Date: 22-Jul-2025
Our Ref: 2025/91633

**TOWN AND COUNTRY PLANNING ACT 1990
TOWN AND COUNTRY PLANNING (GENERAL PERMITTED DEVELOPMENT)
(ENGLAND) ORDER 2015 – SCHEDULE 2, PART 1, CLASS A.1 (g)
AT: 349, Blackmoorfoot Road, Crosland Moor, Huddersfield, HD4 5QU
Prior notification for single storey rear extension**

Ground Floor Layout 1.50

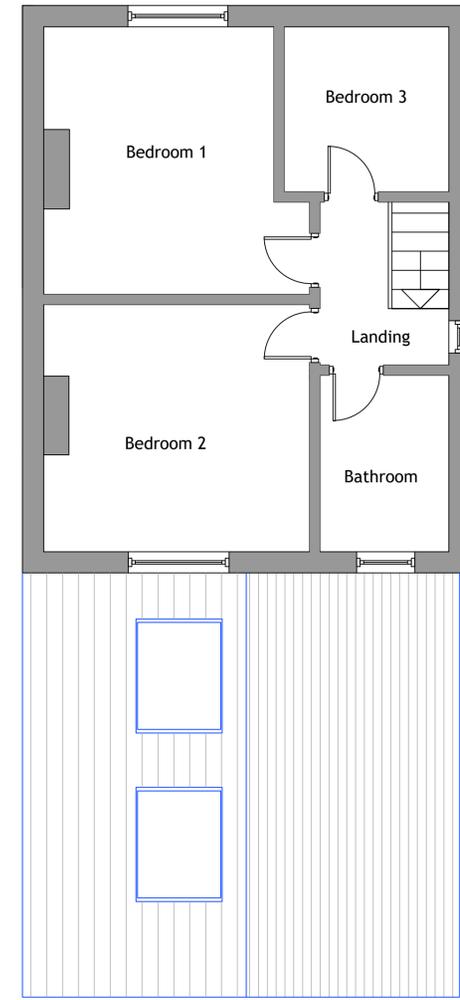
The proposal is for erection of single storey rear extension. The extension projects 6m beyond the rear wall of the original dwellinghouse. The maximum height of the extension is 3.58m, the height of the eaves of the extension is 2.4m

The proposed enlargement does not benefit from a general planning permission under Article 3(1) and Class A, Part 1 of Schedule 2 of the Town and Country Planning (General Permitted Development) (England) Order 2015 as the rear projection extends beyond a wall forming a side wall of the original dwellinghouse and has a width greater than half the width of the original dwellinghouse contrary to sub-paragraph A.1(j) of Class A.
